Applicant: Mr J Stokes

Description: Conversion and extension of building to form apartments

Site Address: Caxton House Surgery, 53 High Street, Grimethorpe, Barnsley, S72 7BB.

0m 1m 2m 3m 4m 5m	
A Layout redesign JS 14/12	
Rev. Description By Date	
Project 53 High Street Grimethorpe Barnsley	
S72 7BB	
Drawing Title Proposed Floor Plans	
Drawing No. high/03 Rev. A Drawn by J.S. Scale 1:50@A1 Date Jul '22

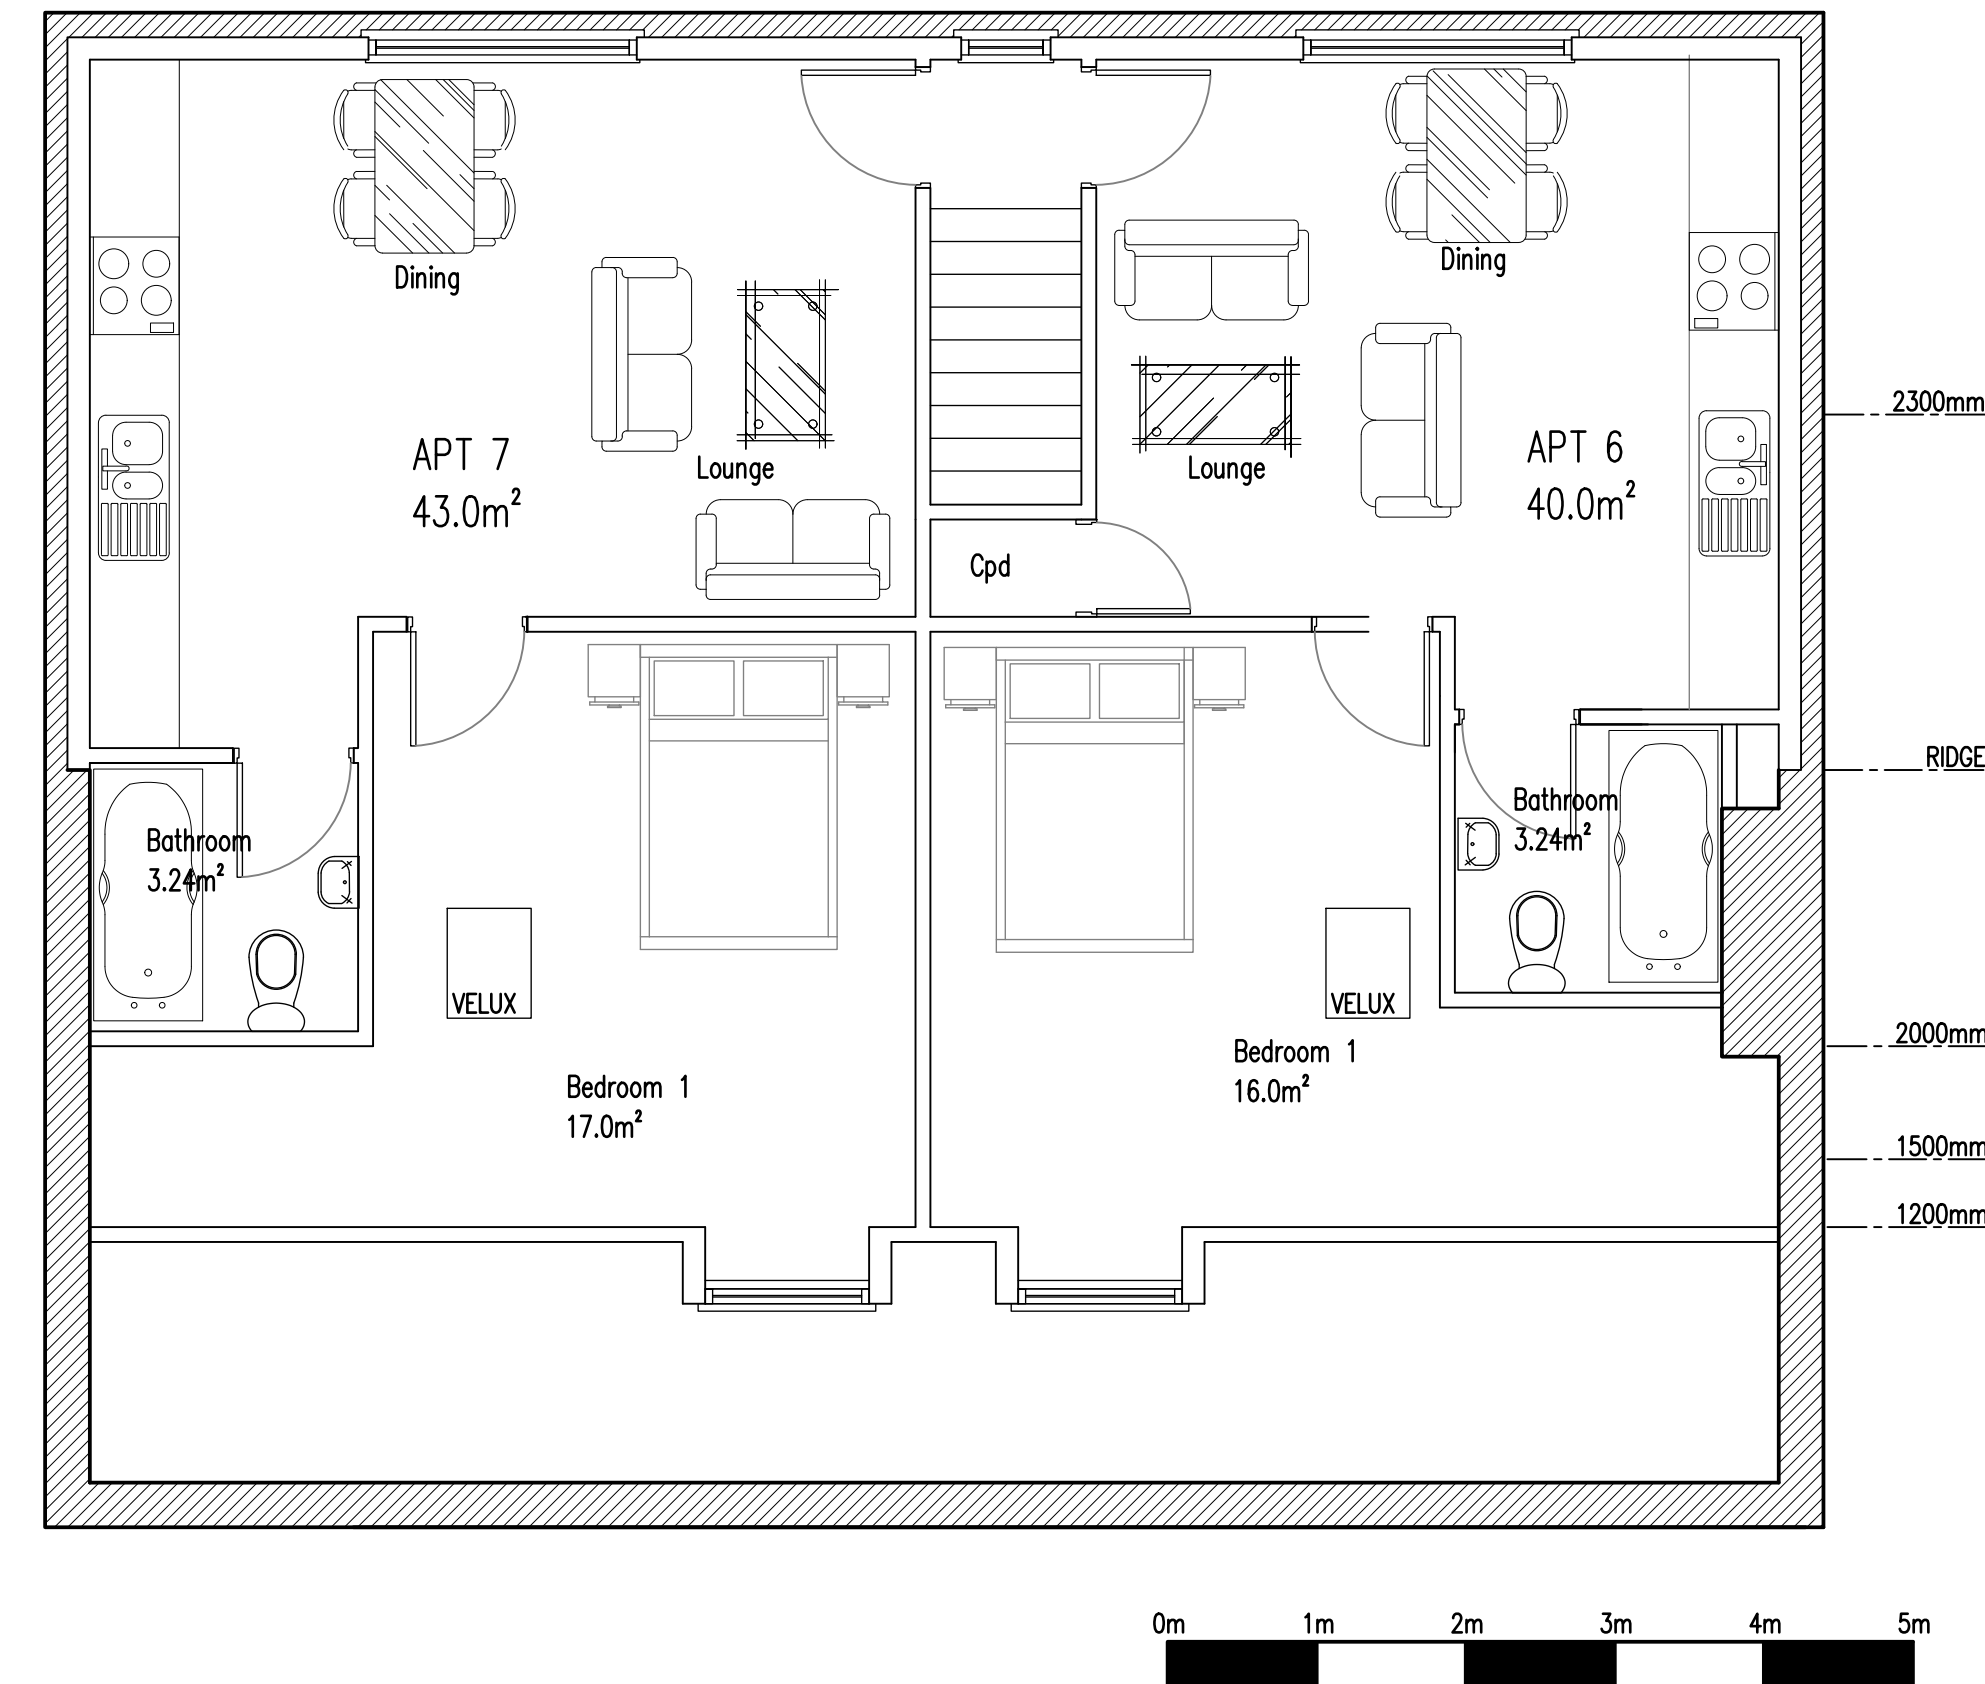
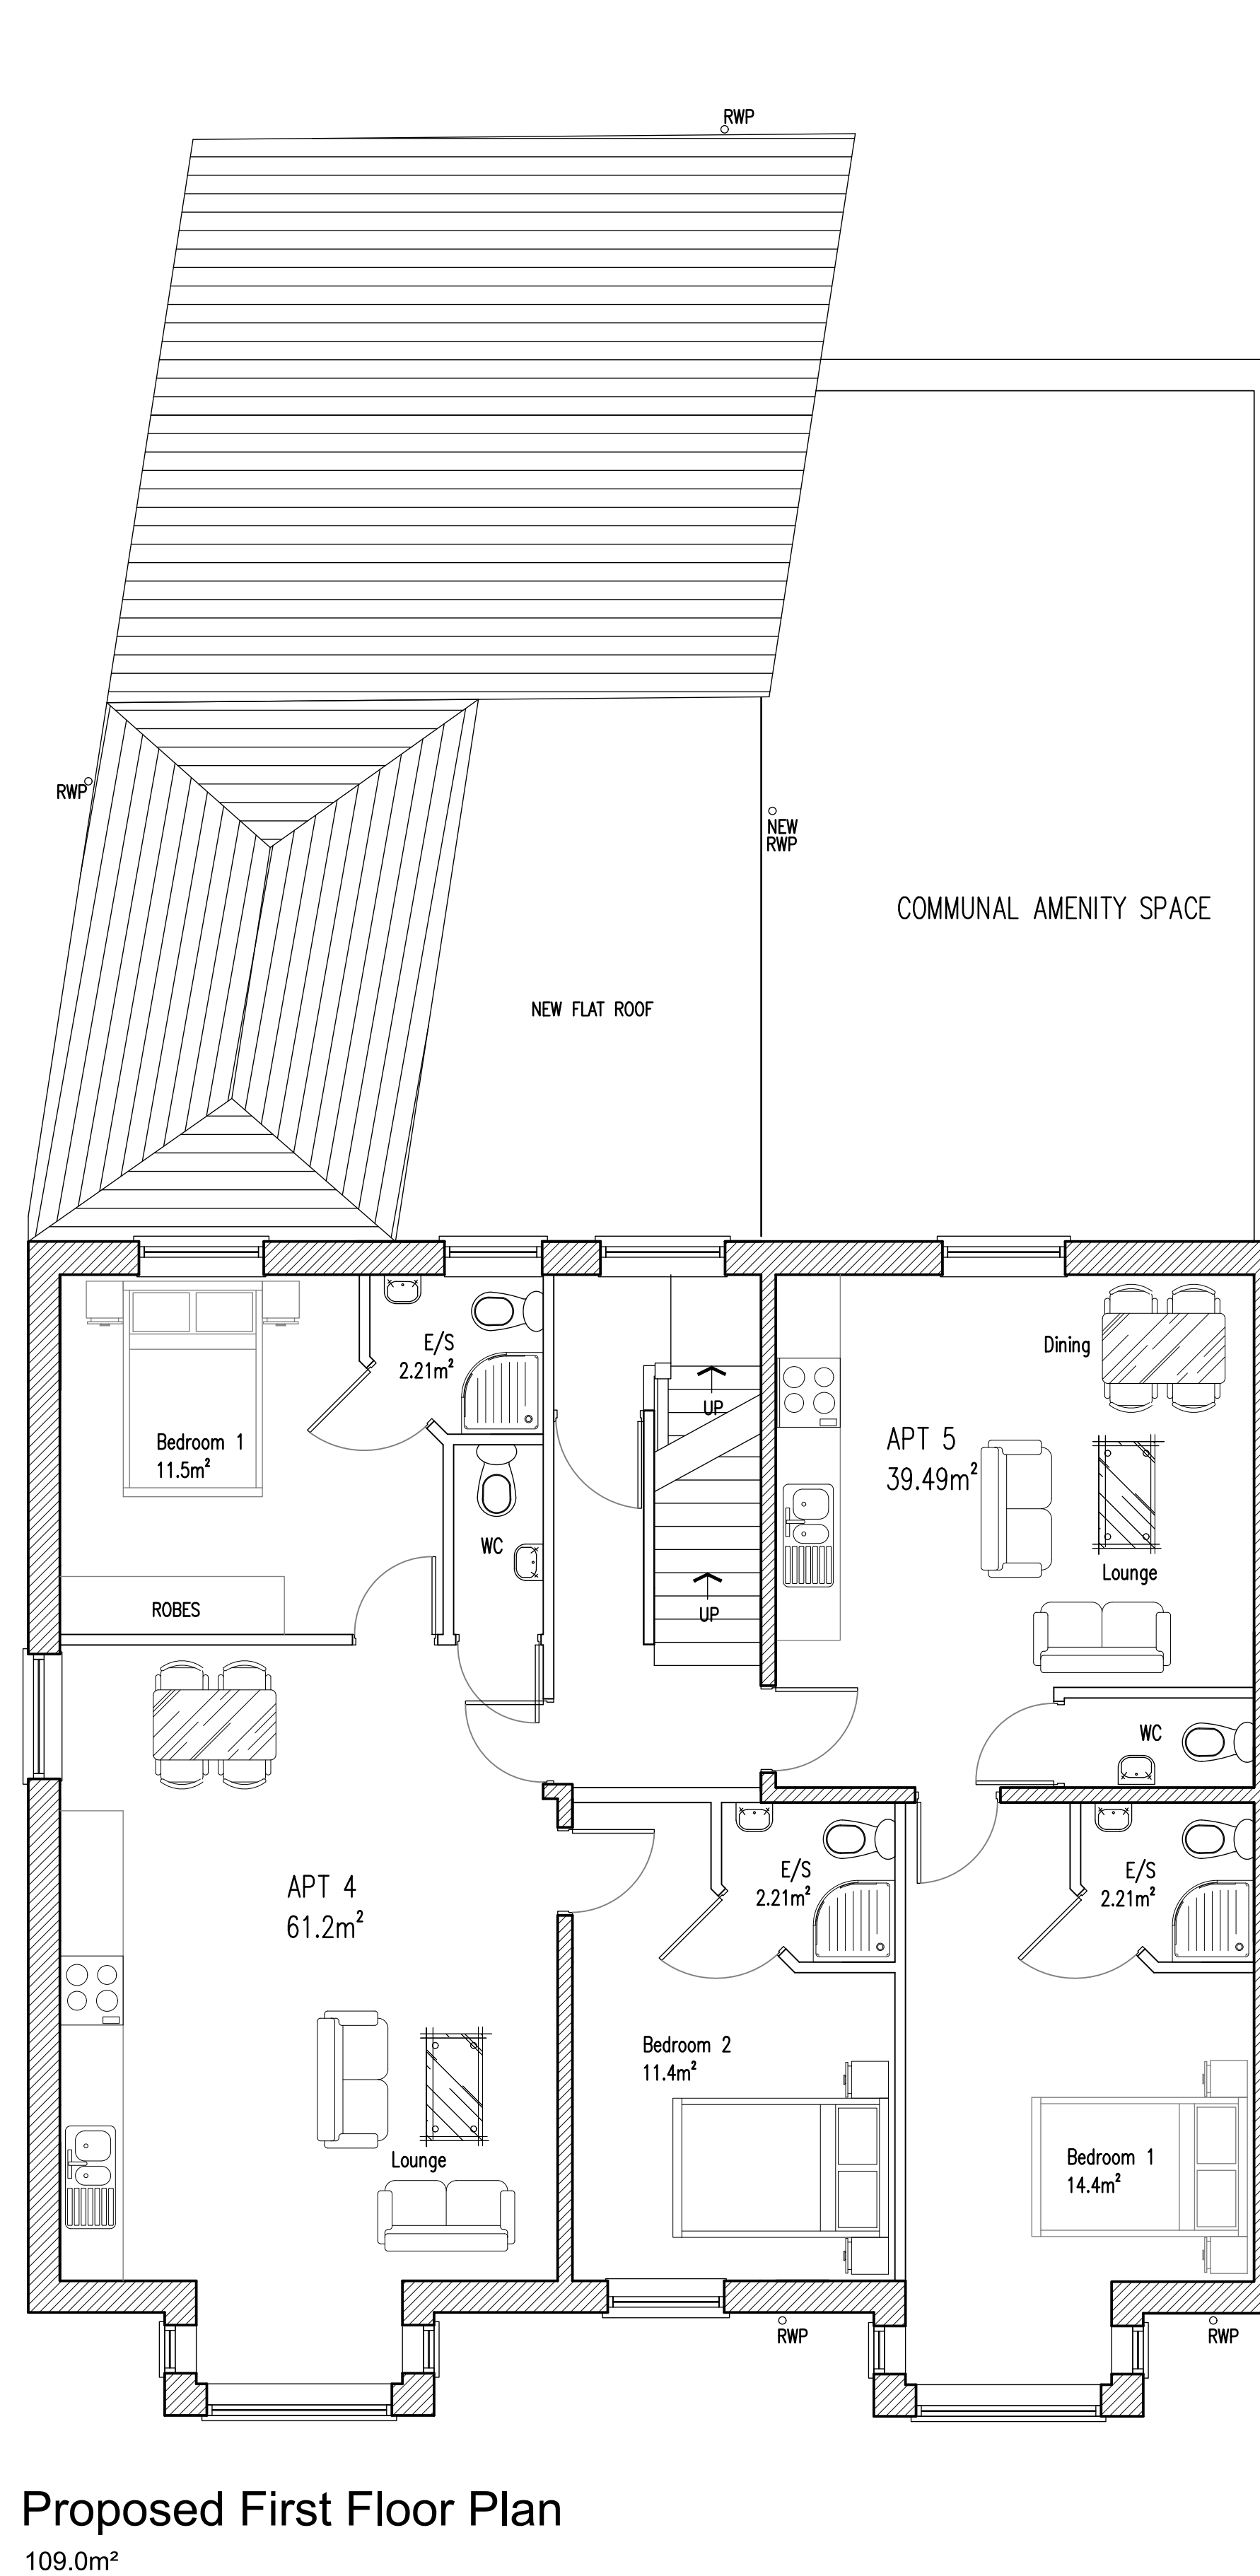
Apartment one and two are both one bed apartments at ground floor. Whilst the individual rooms meet the space standards as per the SYRDG, they both fail to meet the overall standard for a one bedroom apartment (46sqm) as they measure up at 42 and 44sqm.

Apartment three is a 2 bedroom apartment and whilst most of the individual rooms meet space standards, the en-suites are undersized and do not meet the standard of 3.5sqm and the overall standard of 62sqm is not met as the apartment measures up at 58.6sqm.

Apartment four is a one bed apartment and has an undersized kitchen/diner/lounge (KDL) at 21.3m (standard is 24sqm), an undersized en-suite at 2.21m (bathroom should be 3.5sqm) and the overall standard of 46sqm is not met as the apartment measures up at 38.19sqm.

Apartments five and six are both one bed apartments at second floor and follow a similar layout. The combined KDLs in both apartments are undersized measuring at 23.7 and 20.85sqm and the overall standard of 46sqm is not met as the apartments measure 42.4 and 39.85sqm.

All habitable room windows are served by windows which would provide a good outlook and amount of light into the apartments. The windows serving the bedrooms of apartment five and six are smaller than the other windows however this is a betterment over the rooflights over the previously refused application and the proposed elevations show that the windows will open allowing for daylight.
